Application Ref:	2026/0301			 Ribble Valley Borough Council www.ribblevalley.gov.uk
Date Inspected:	24/06/2026	Site Notice:	24/06/2026	
Officer:	EP			
DELEGATED ITEM FILE REPORT:				APPROVAL

Development Description:	Proposed erection of single-storey porch extension to side elevation, introduction of two new window openings in either side elevation at second floor level and new rooflight in principle roofslope.
Site Address/Location:	Well House Main Street Grindleton Clitheroe BB7 4QT.

**Proposed Second Floor Plan**  
Scale @ A1: 1:50

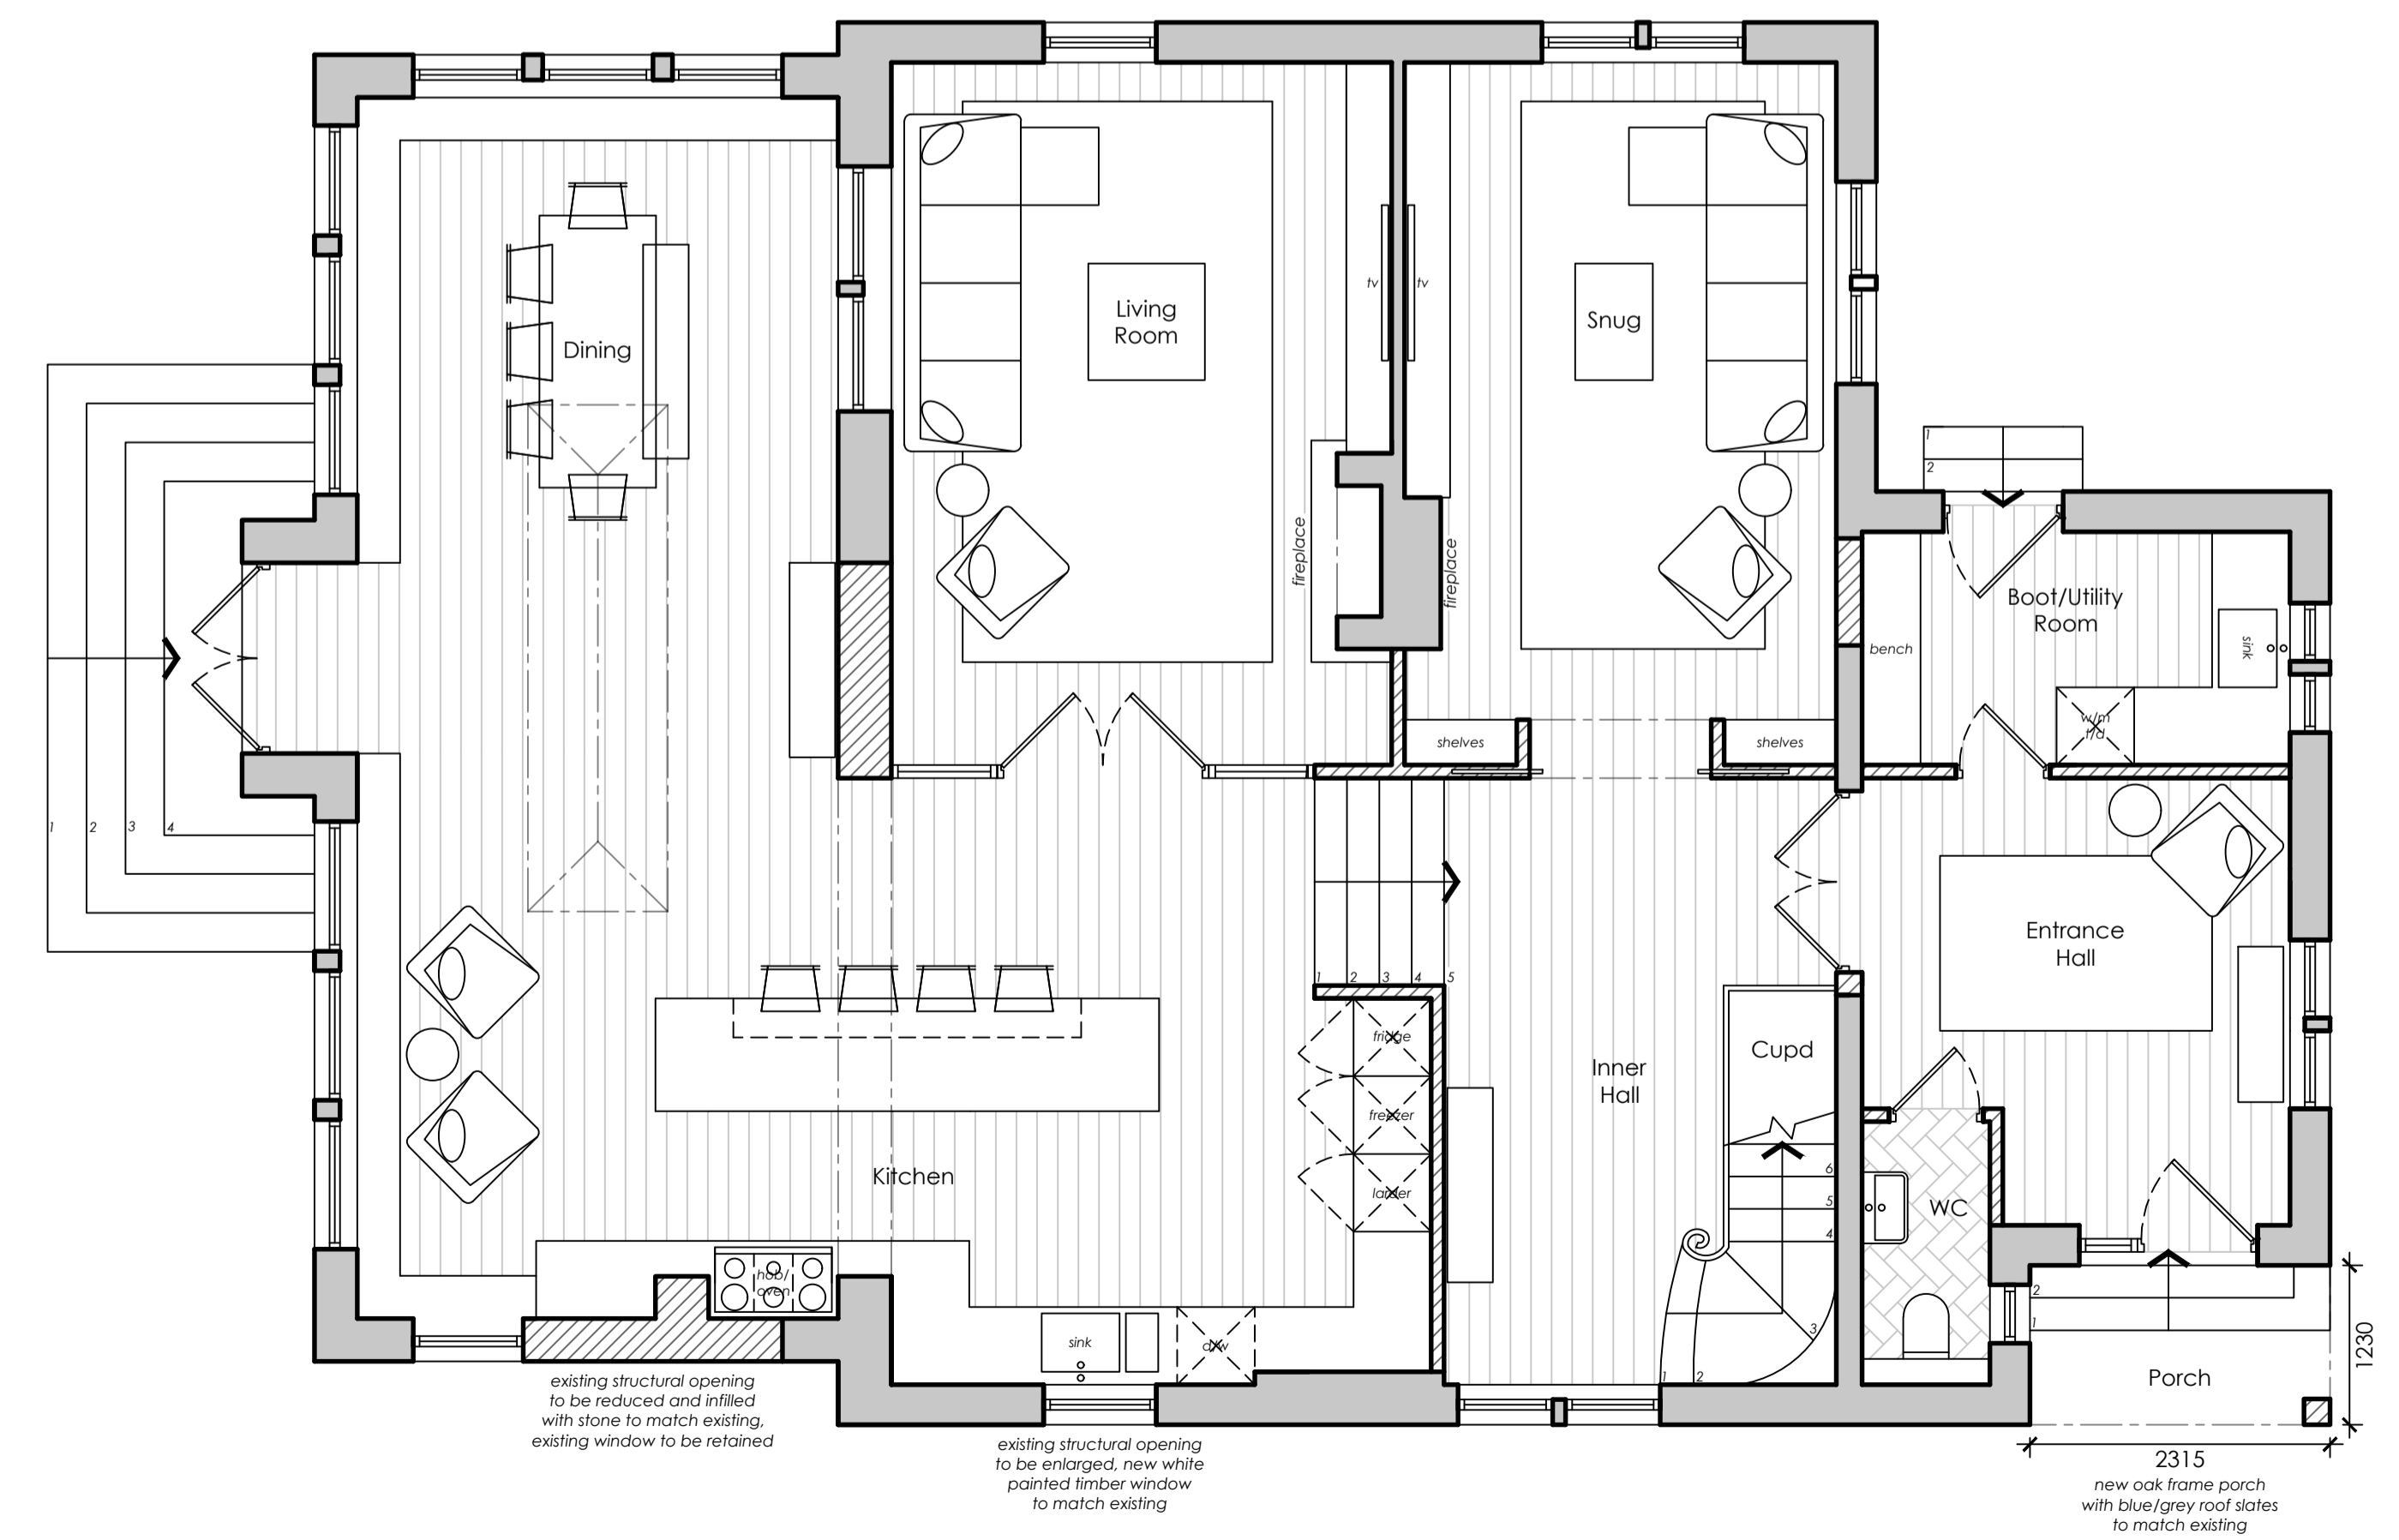
The proposed second floor windows are located within the side elevations of the dwelling and therefore limited views of these would be afforded from within the street scene. Nonetheless, these will be timber framed to match the dwelling and will integrate sufficiently into the street scene.

There are two new window openings proposed at second floor level. The application dwelling is set back from the linear form of the road and as such is set behind its neighbouring dwellings. As a result, the proposed new windows do not create opportunity for direct overlooking. There may be a slight perception of overlooking created for the receptor to the south. This can be mitigated through obscure glazing, which can be secured via planning condition.
